ENG-PUDSP21001-R1-GEC-Redlines.pdf Markup Summary

PUDSP-21-001

VTC-1. AGGREGATE VEHICLE TRACKING CONTROL

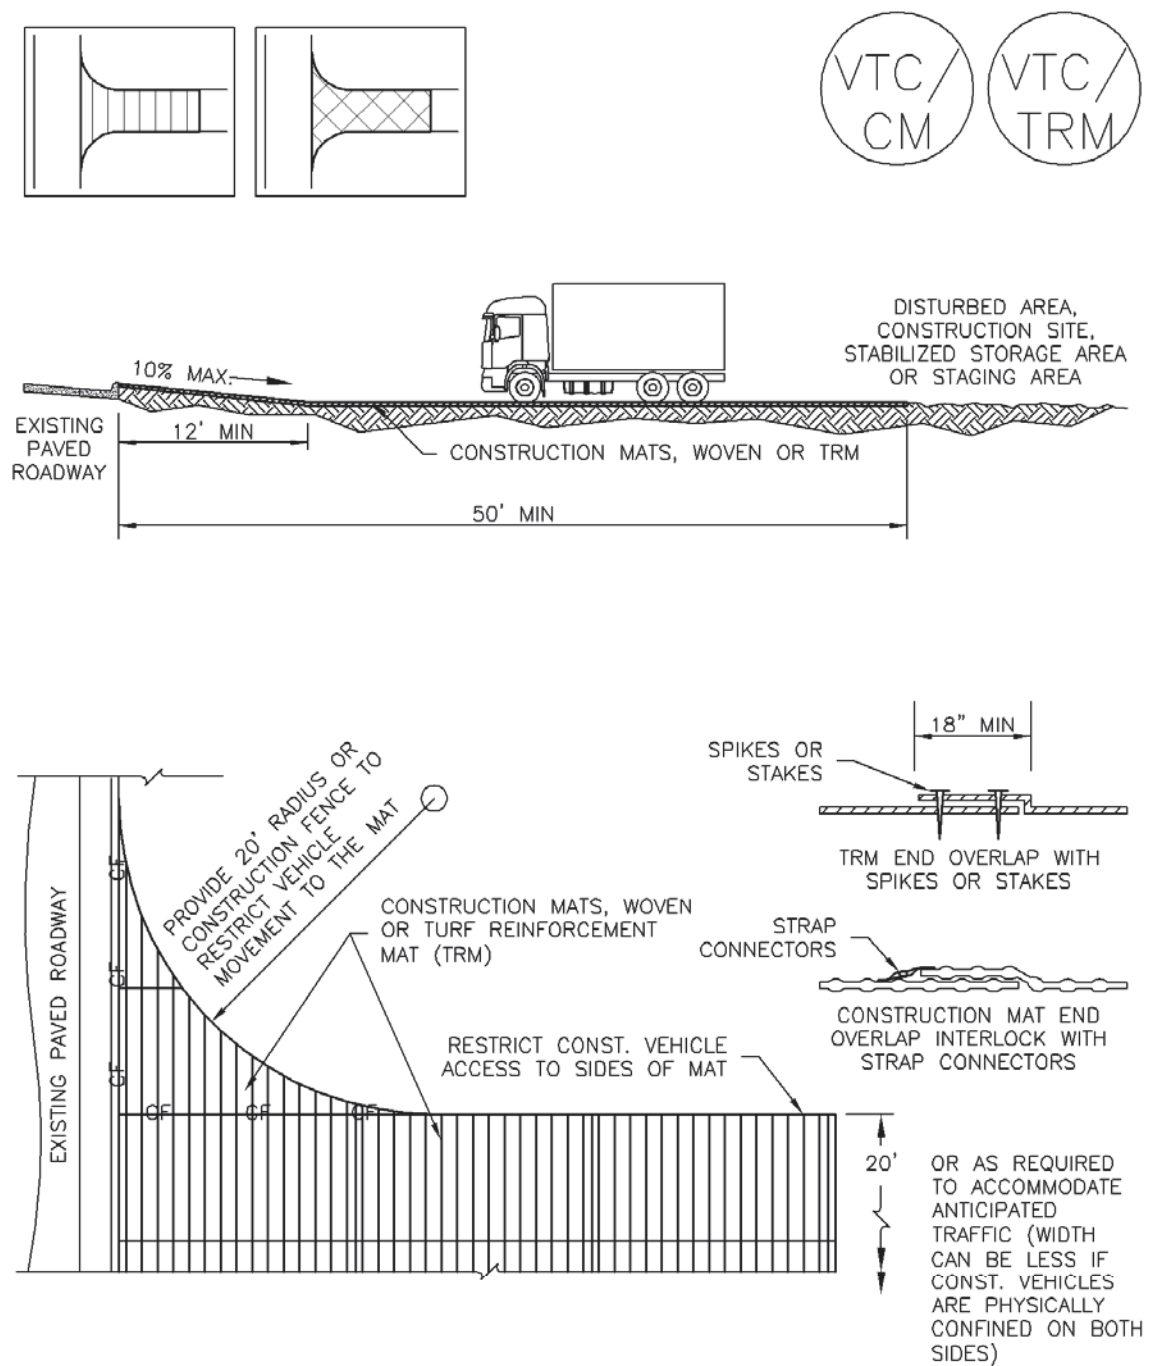
replace with EPC approved VTC detail (VT-1 and VT-2 in DCM Vol. 2, Chap 3.3) or revise to be 75ft min length
